Response to Submissions - SSDA 10371

Trinity Grammar School - 'The Renewal Project'

119 Prospect Road, Summer Hill
Lot 11 1171965

State Significant Development SSDA 10371 - Response to Submissions

VP5 View from adjacent to 175 Victoria Street

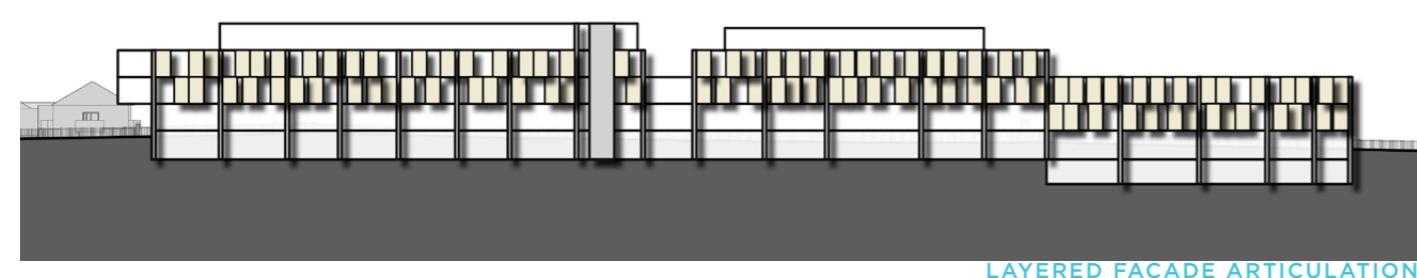
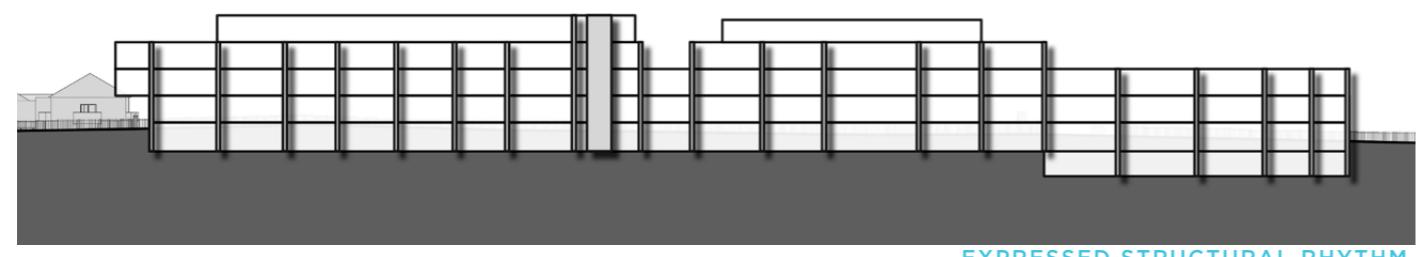
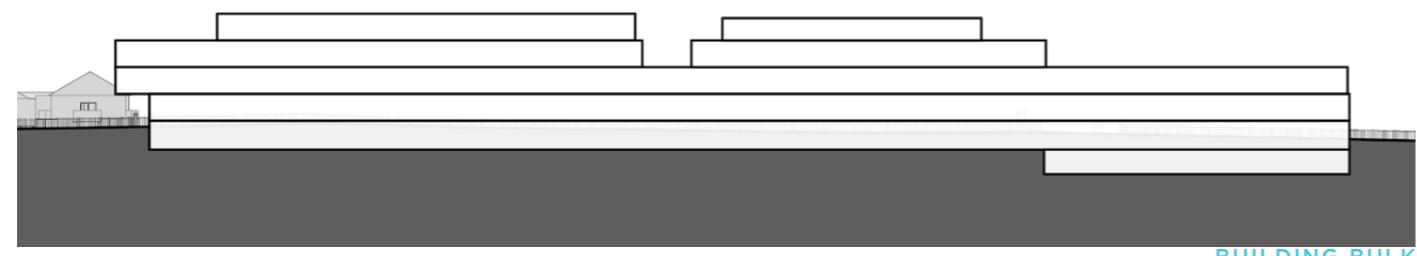
Whilst DPIE recognised that any view loss caused by the proposed development was low to moderate, further consideration was requested around the design options to explore whether the overall height and bulk of the five-storey built form may be produced.

The design and scale of the proposed development reflects the operational requirements of the school. Therefore, in response to the issues raised during the exhibition period, the building envelope of the new building has been reduced, by **500mm, RL69.30 to RL68.80**, to the top of the teaching and learning facility, and **400mm, RL68.60 to RL68.20**, from the top of the mechanical enclosure, resulting in a **2.6%** reduction in building height.

Figure 1 and **Figure 2** below illustrates the revised photomontages indicate the extent of the height reduction. The red dashed line indicates the original building height in comparison to the revised building height.
